RE: Response to Submissions Tweed Sand Plant Expansion, Cudgen Tweed LGA (SSD 10398)

Attachment 1: Detailed BCD Comments – Response to Submissions for the proposed Tweed Sand Plant Expansion at Cudgen

SECTION C
1:150 AT A1

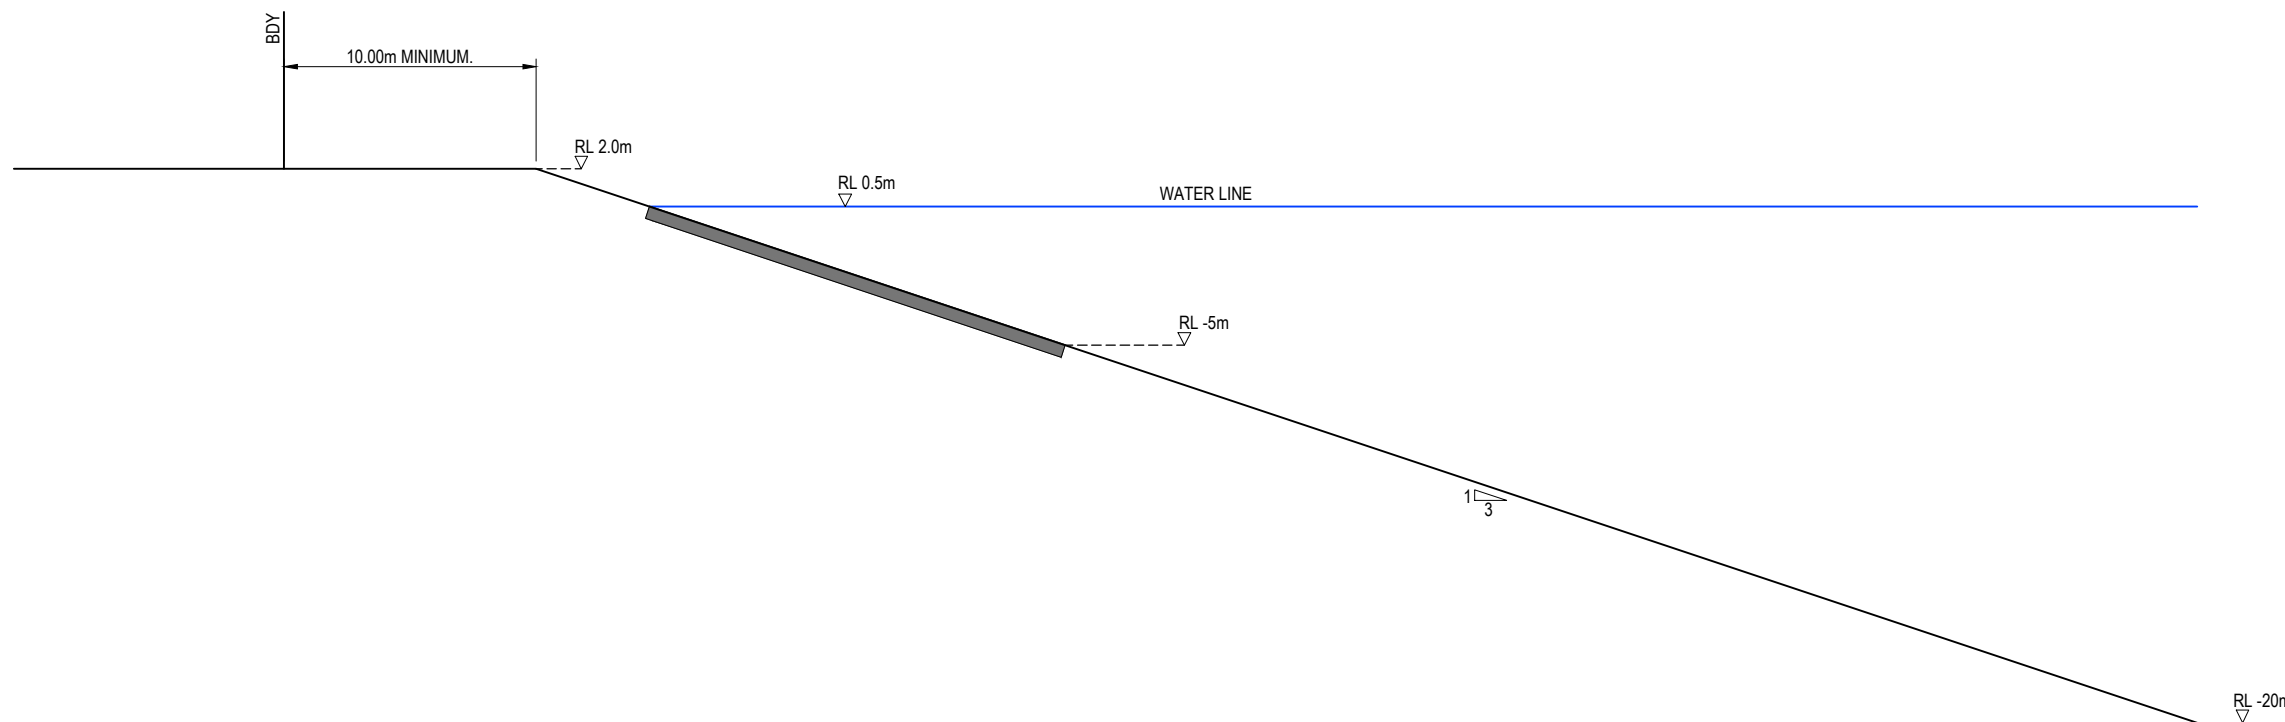
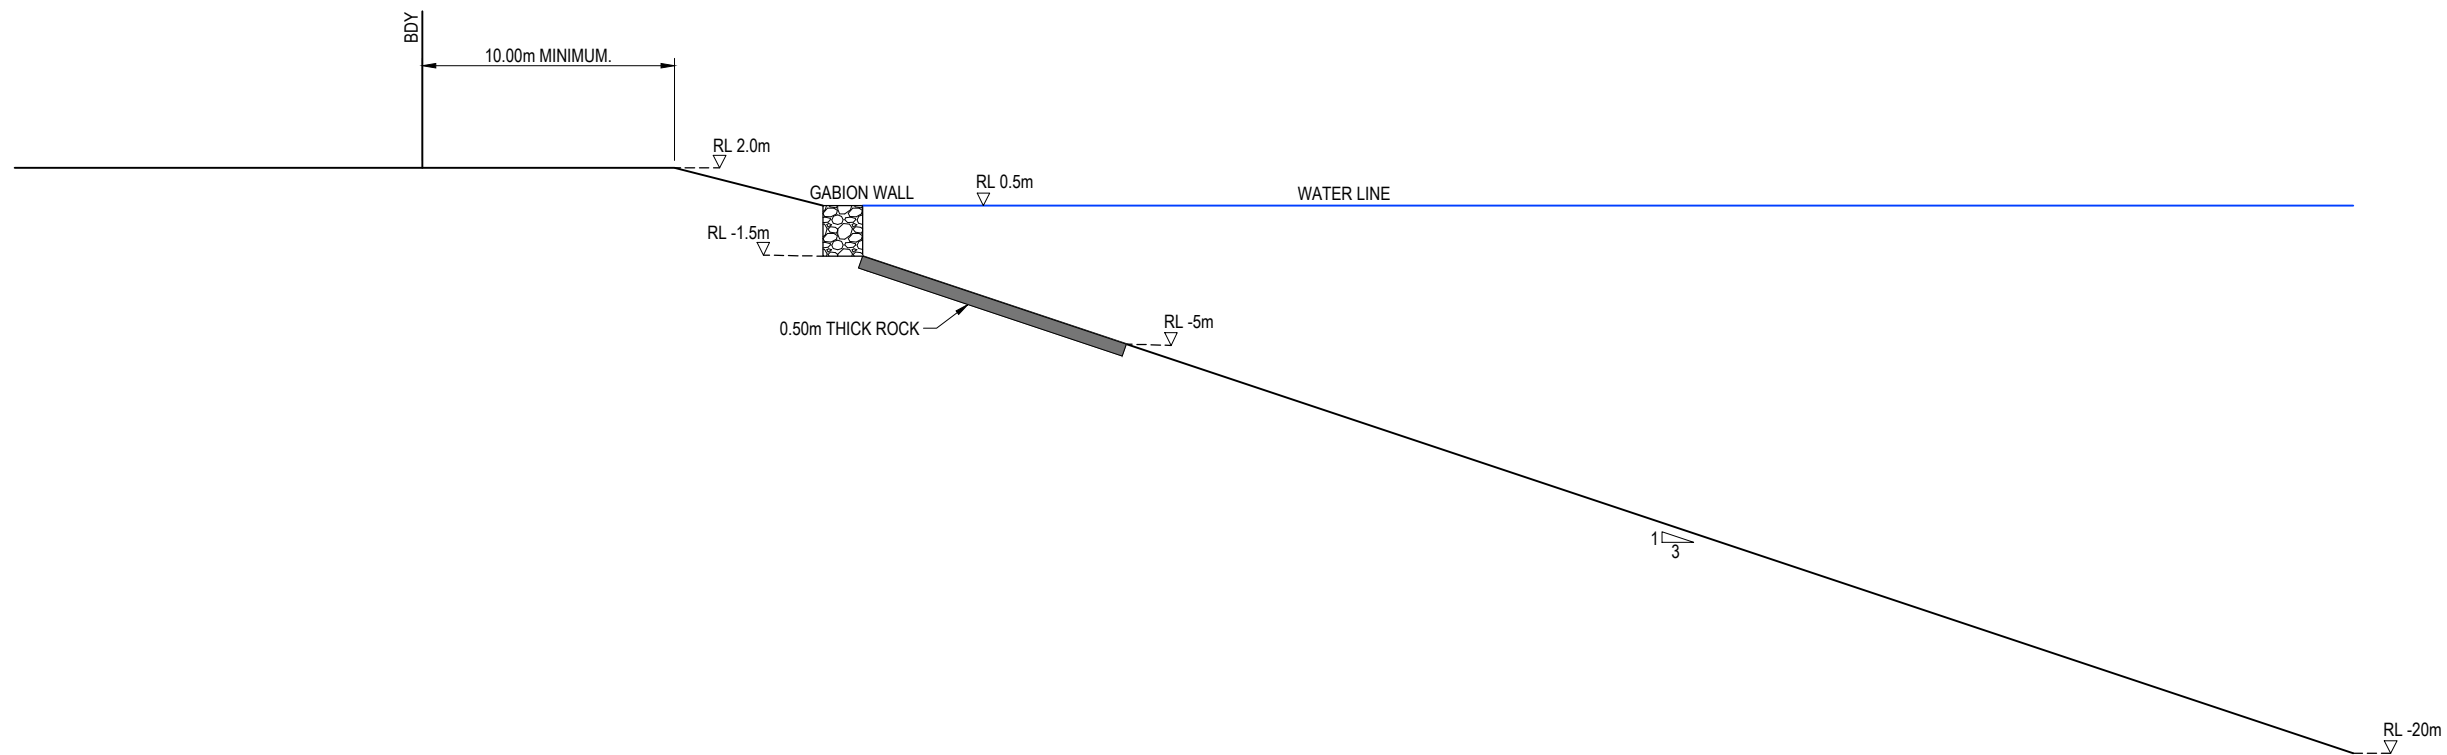
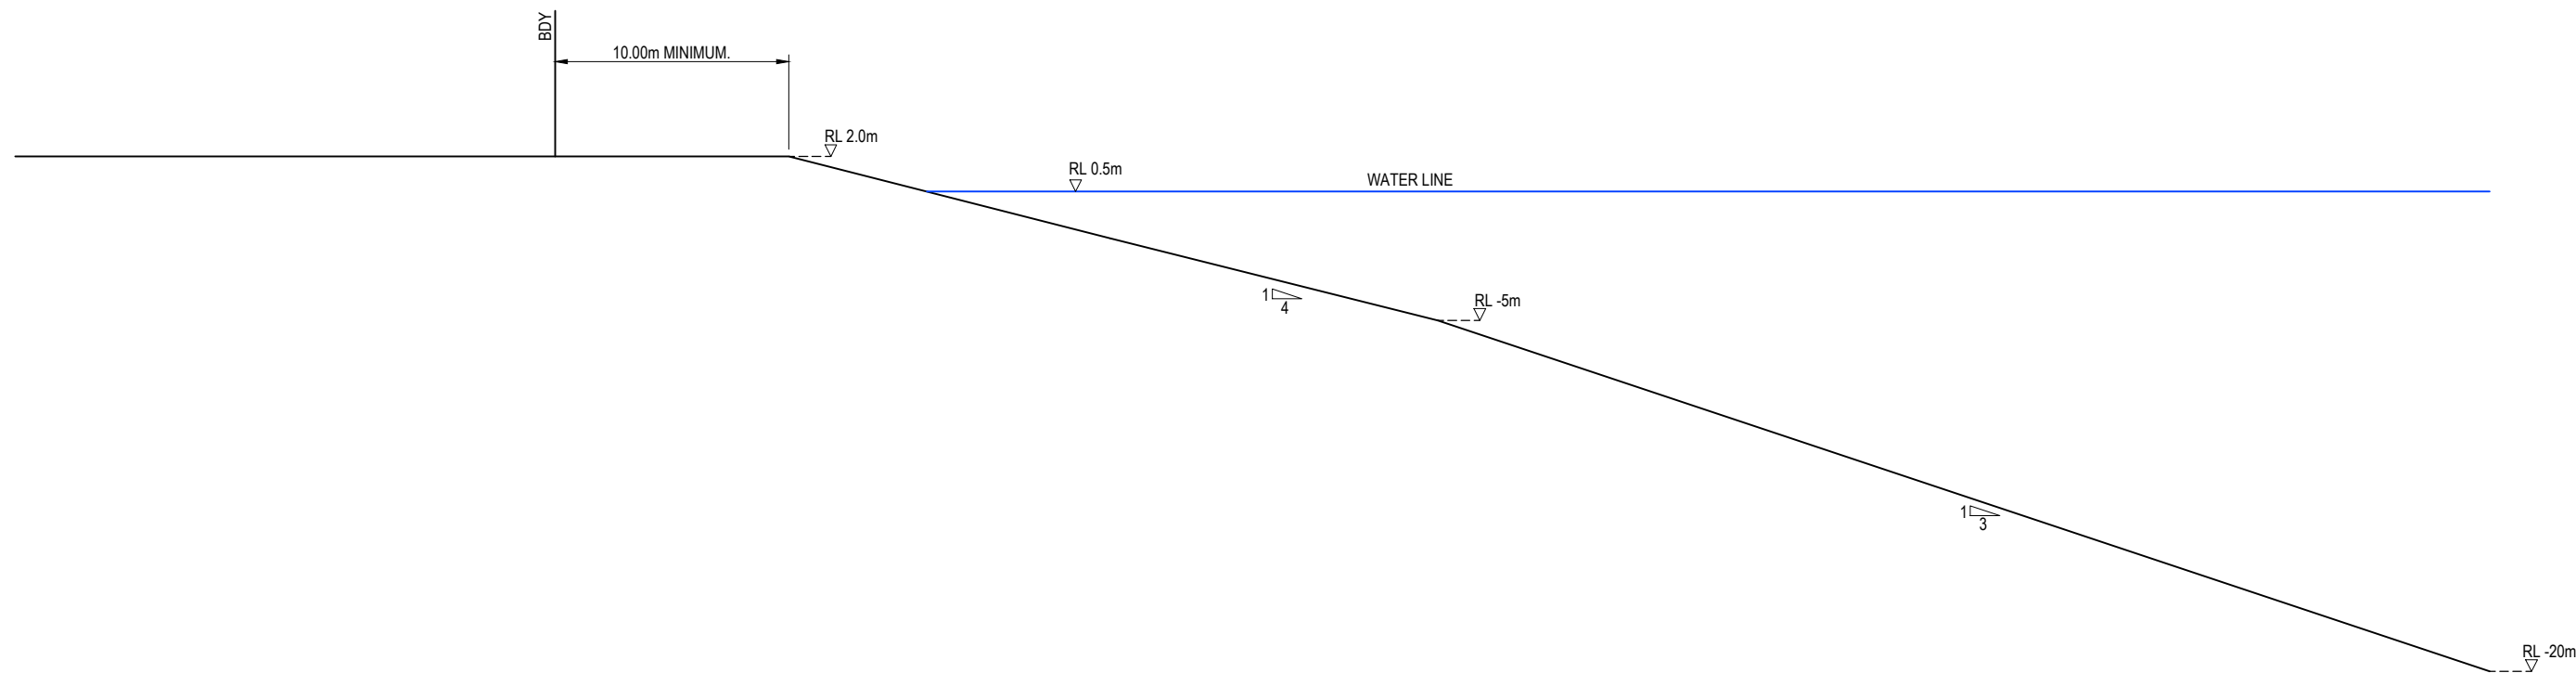
The BCD does not consider the rehabilitation arrangements as described in the Concept Rehabilitation and Landscape Management Plan (CRLMP) prepared by JWA dated November 2021 adequately meet the above Strategic Framework principles. The proposed rehabilitation involves small, linear strips of vegetation around open bodies of water. These strips will become increasingly waterlogged and degraded over time as described in the SRT (p2):

The proposed final phase of the project is for large open water bodies where the sand has been extracted with limited rehabilitation areas around the fringes of the water bodies. These areas will have limited biodiversity or recreational values. As noted above, the SRT states “if an appropriate alternative use cannot be found for the site” the land will be retained in private ownership (Hanson). Such areas would require ongoing management and monitoring to protect water quality and other environmental values. It is not clear how such management and monitoring would be funded by the company once it has completed its extraction operations at the site.

The final rehabilitation will result in large bodies of standing open water. No specific goals for the end-use water quality have been established as discussed in the Surface Water Assessment Appendix B to the EIS by Gilbert and Sutherland.

2. The rehabilitation plan should be amended to describe how the land will be restored to viable, self-sustaining ecosystems that will provide diverse and flourishing habitats for native species and should also demonstrate clear measurable targets, timeframes, responsibilities, monitoring and performance criteria for these works that will enable future oversight.
